BRITISH HORSE SOCIETY – BEDS – COMMENTS ON DRAFT ASI ITINERARY (REP1-065)

At Deadline A, the BHS requested that the ExA visit Pertenhall BW26 and Bolnhurst & Keysoe BW37, identifying a number of points for the ExA to consider:

© Crown copyright and database rights 2025.
Ordnance Survey AC0000808122

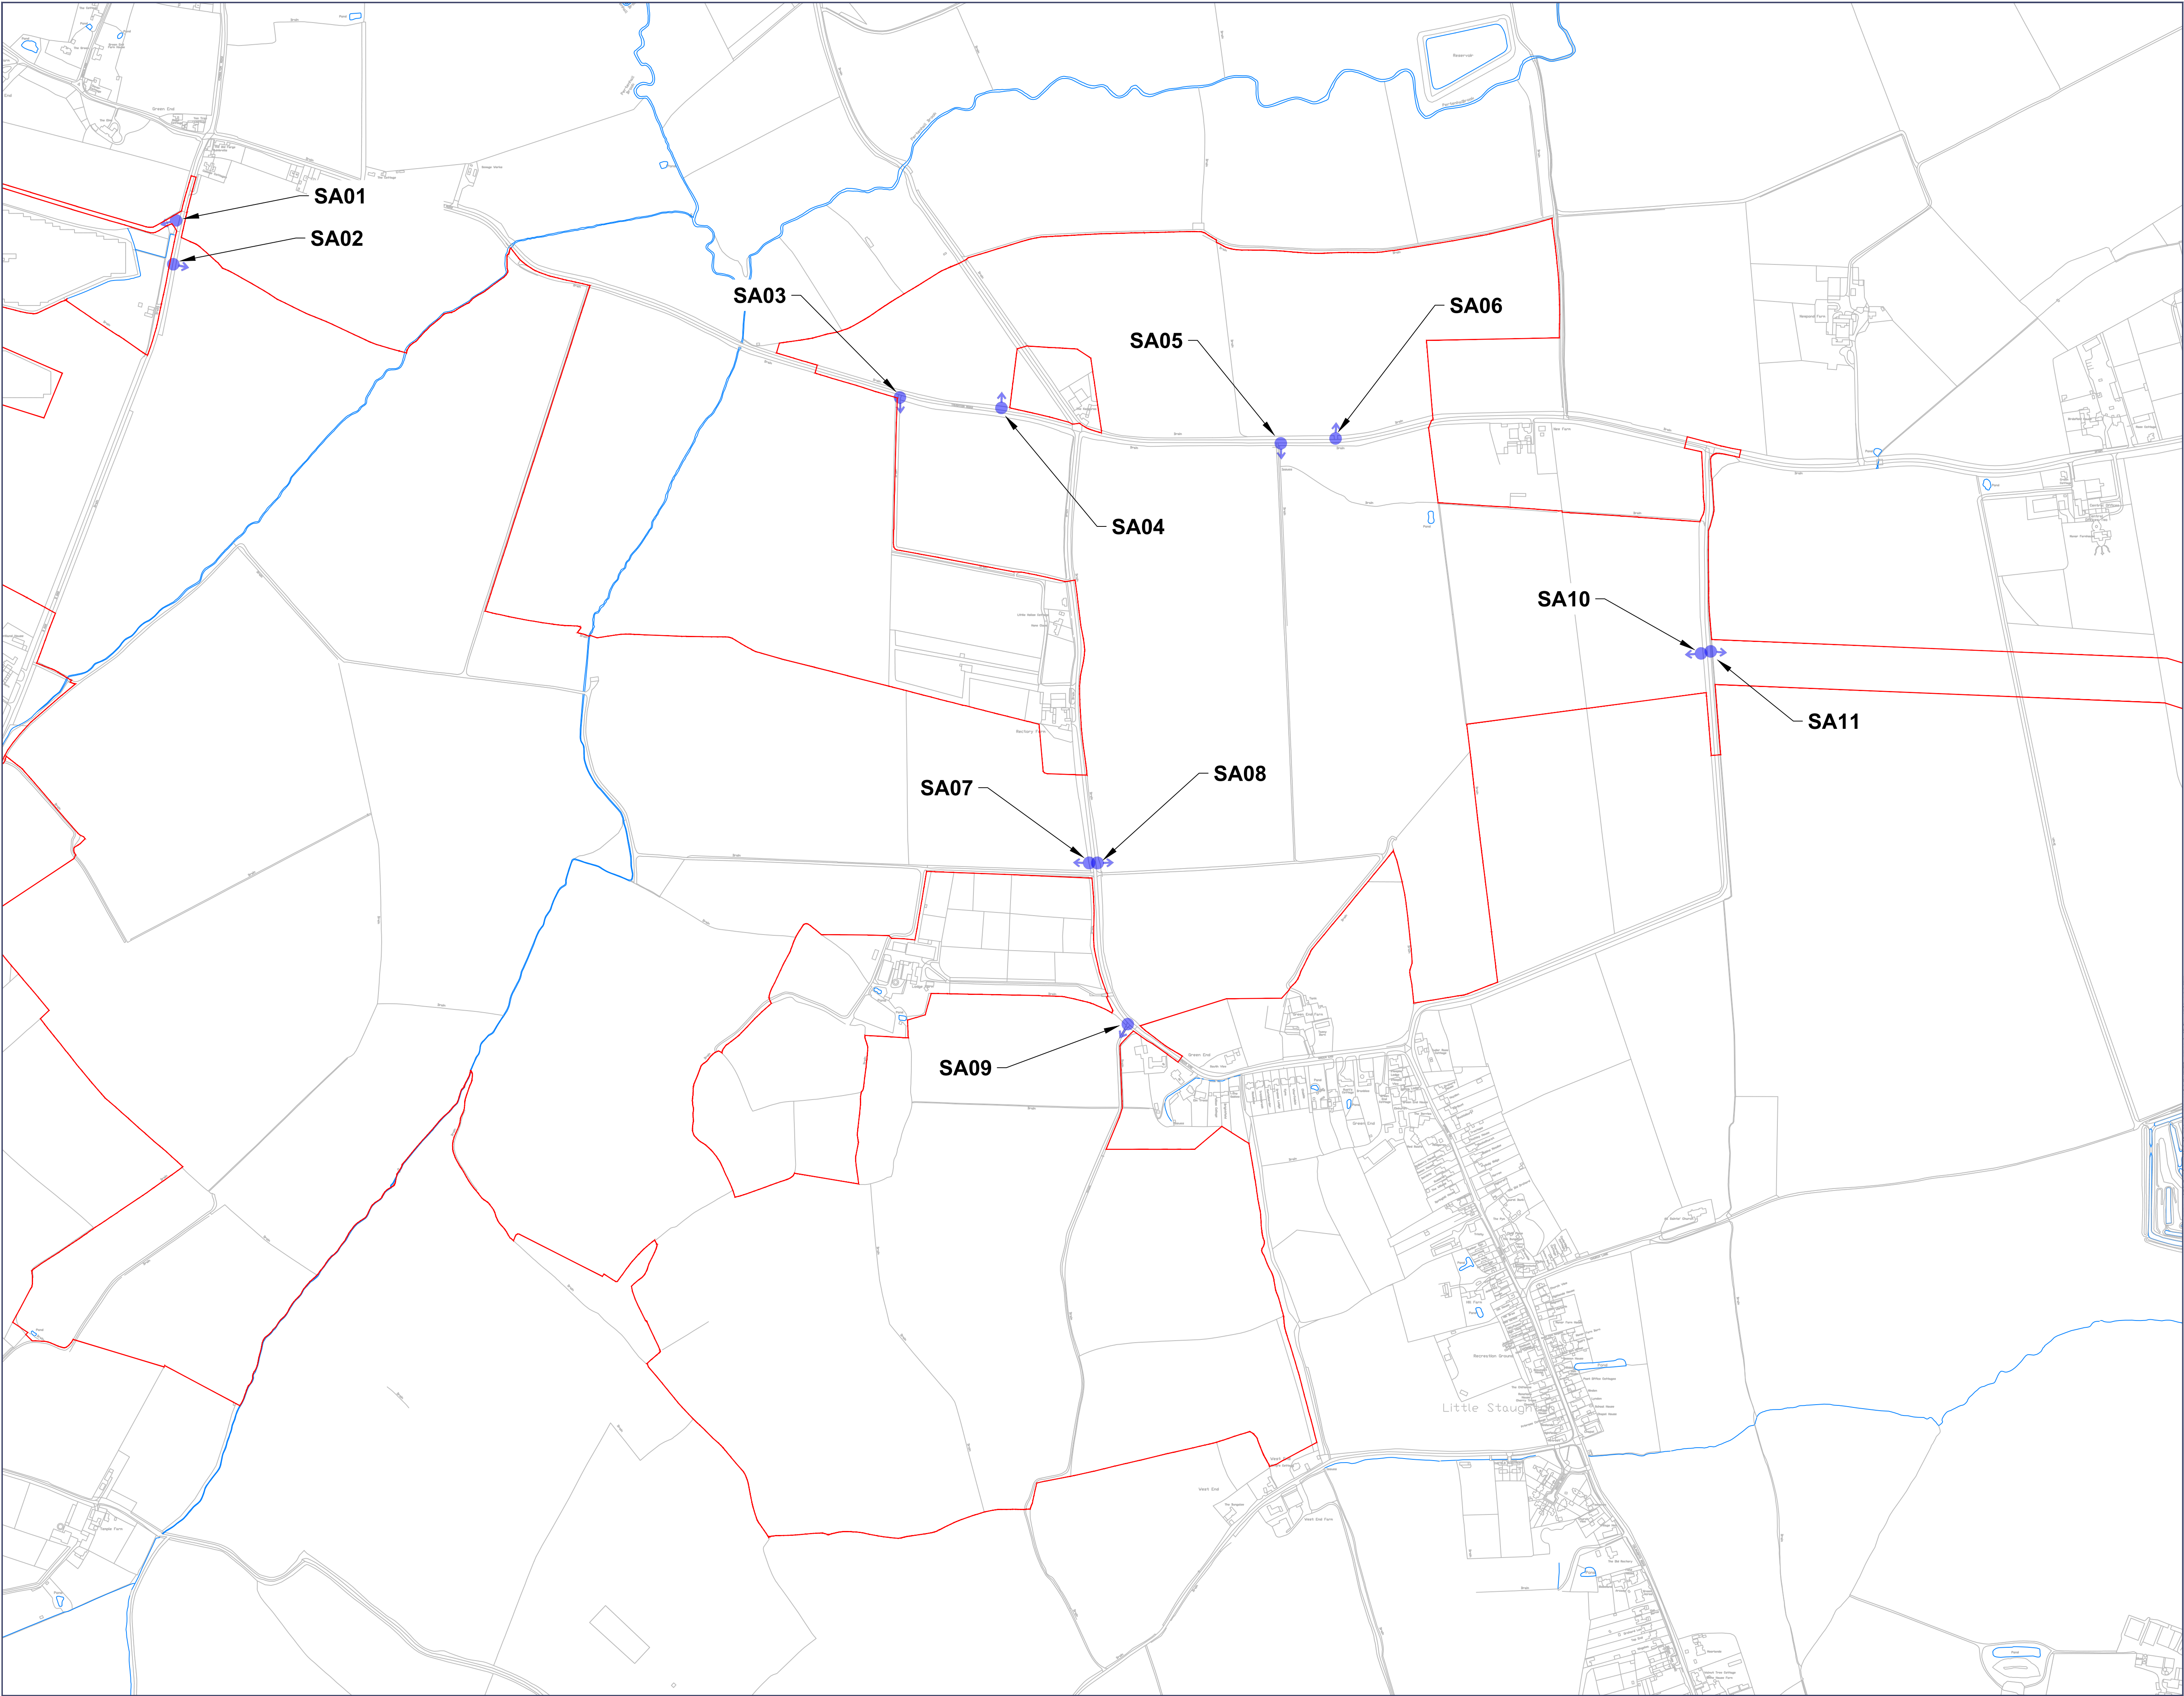
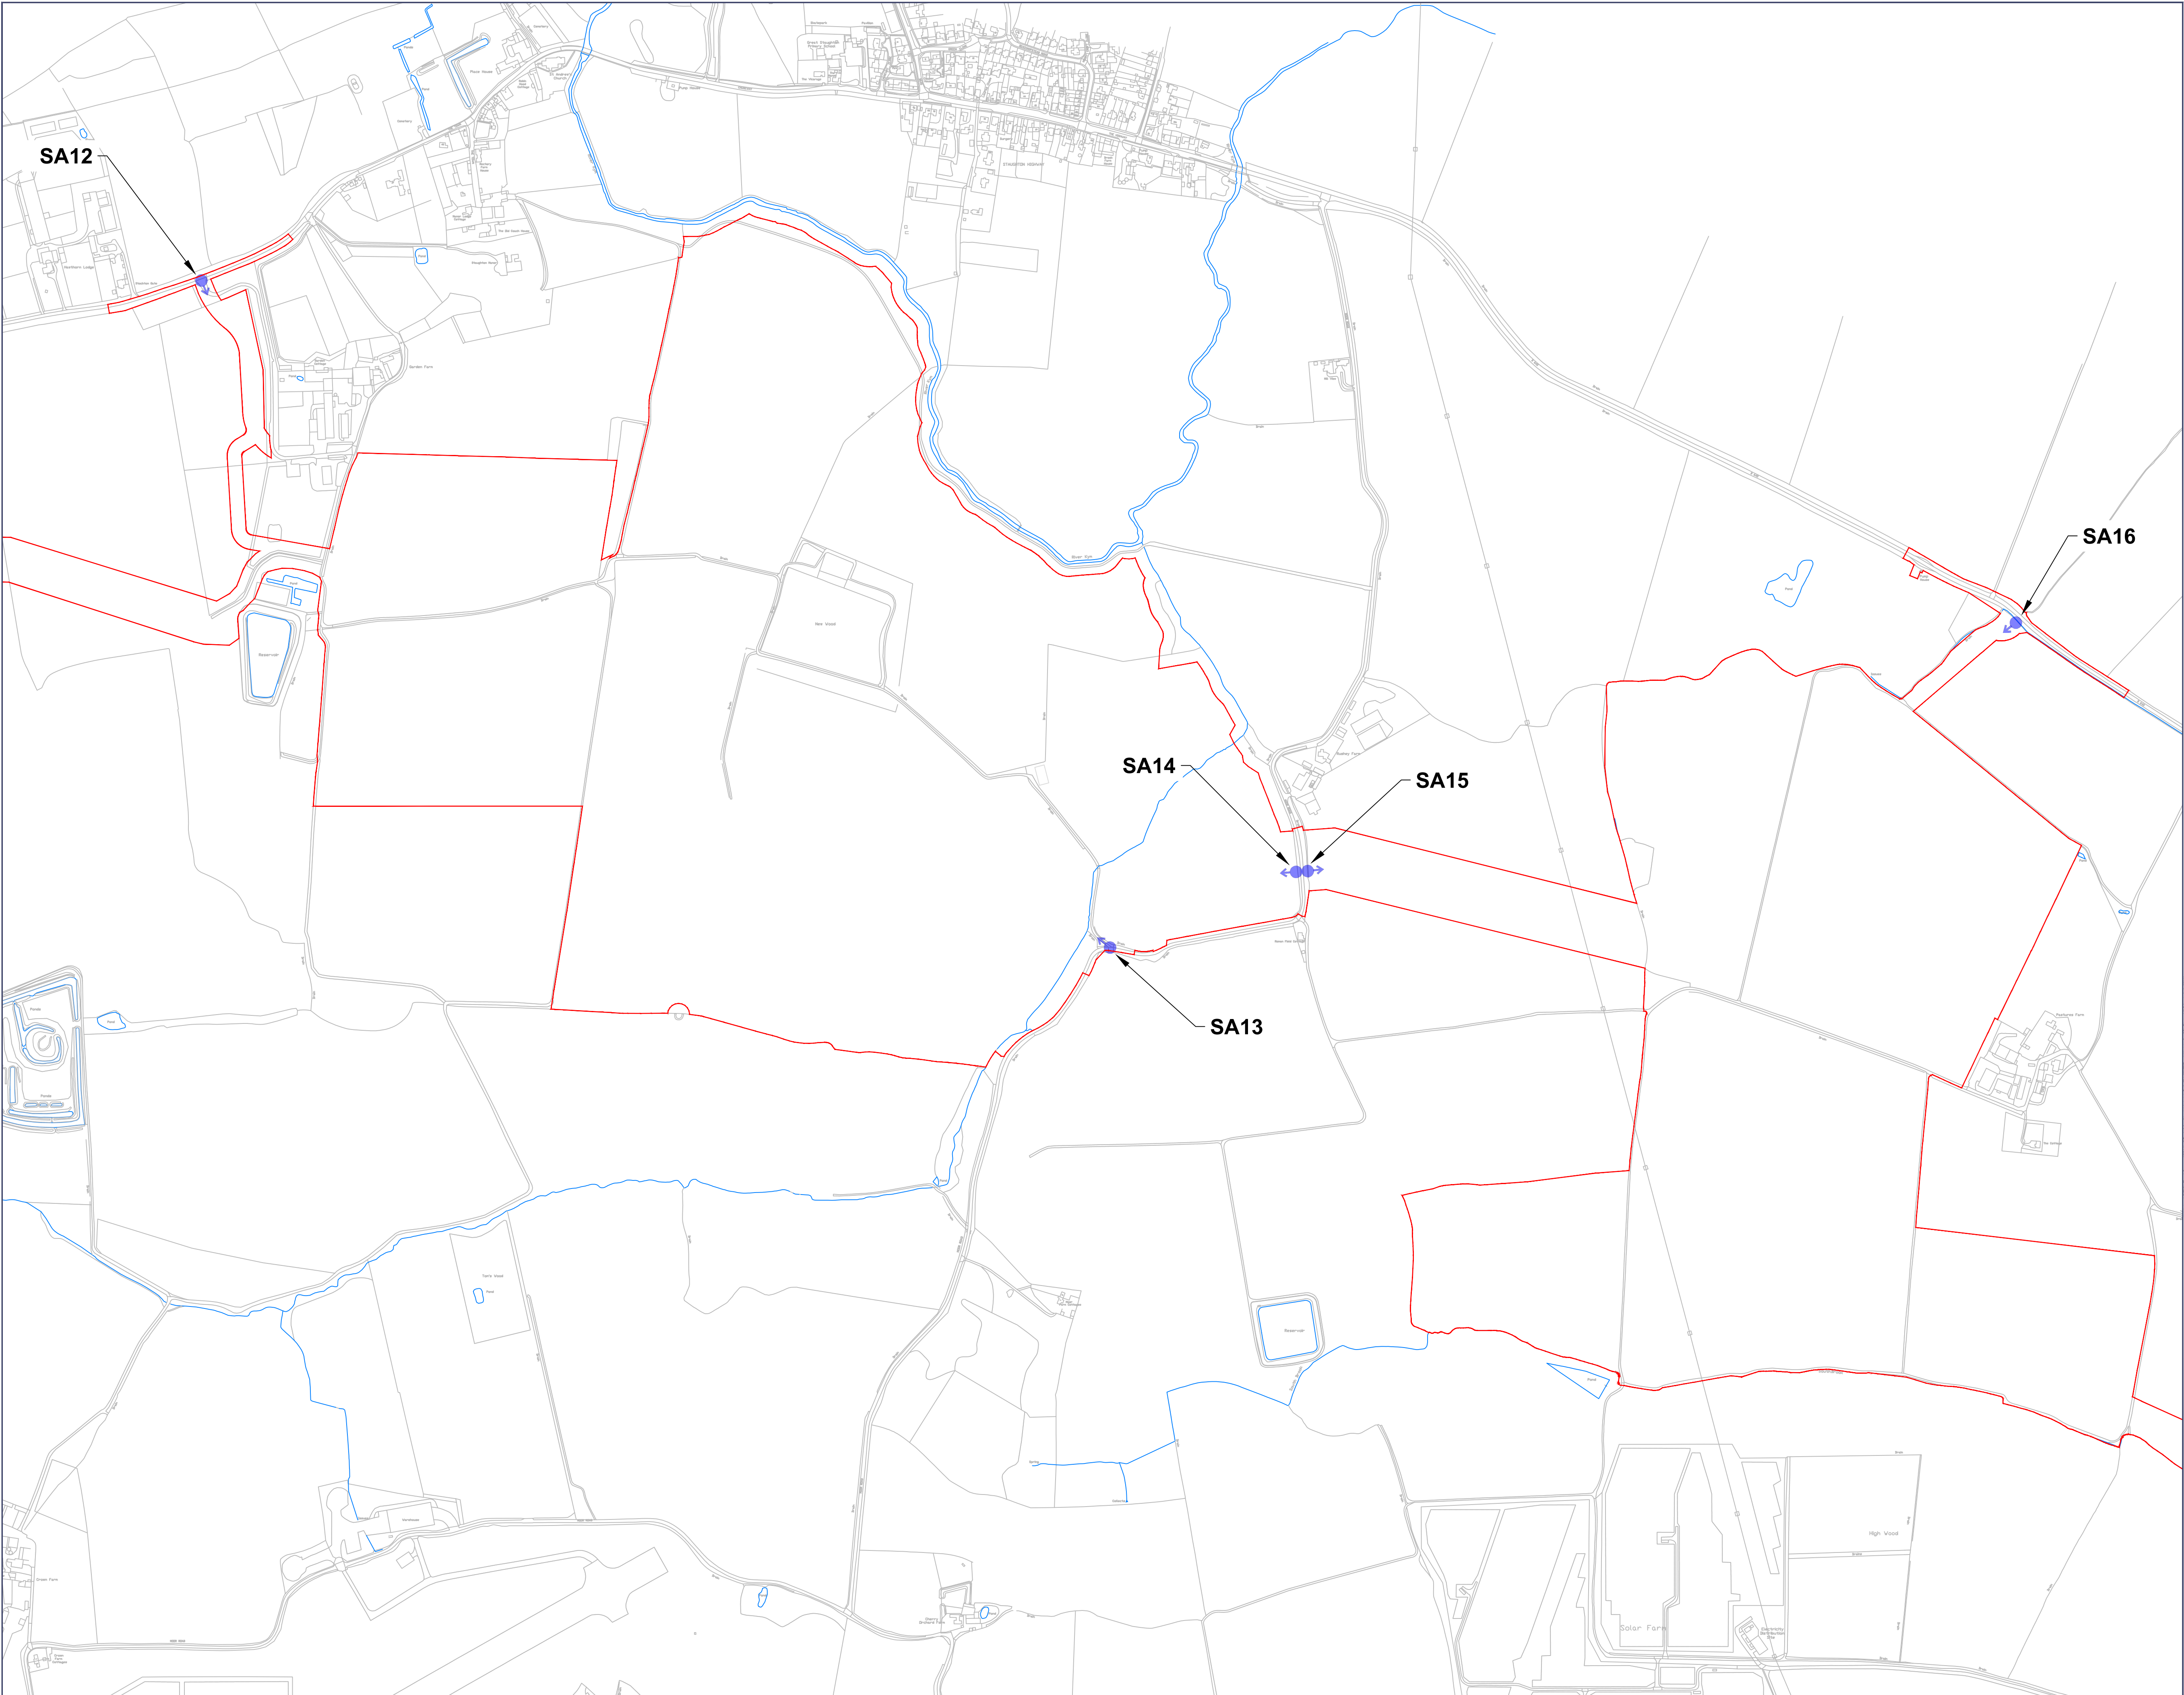
Between C and D, the Justification column of the itinerary refers to SA12 but not to the site access just before D, which curiously is not labelled on the Site Access plan (APP-124).

Likewise, the itinerary justification between D and E should refer to SA05. And the route should be extended to visit SA03.
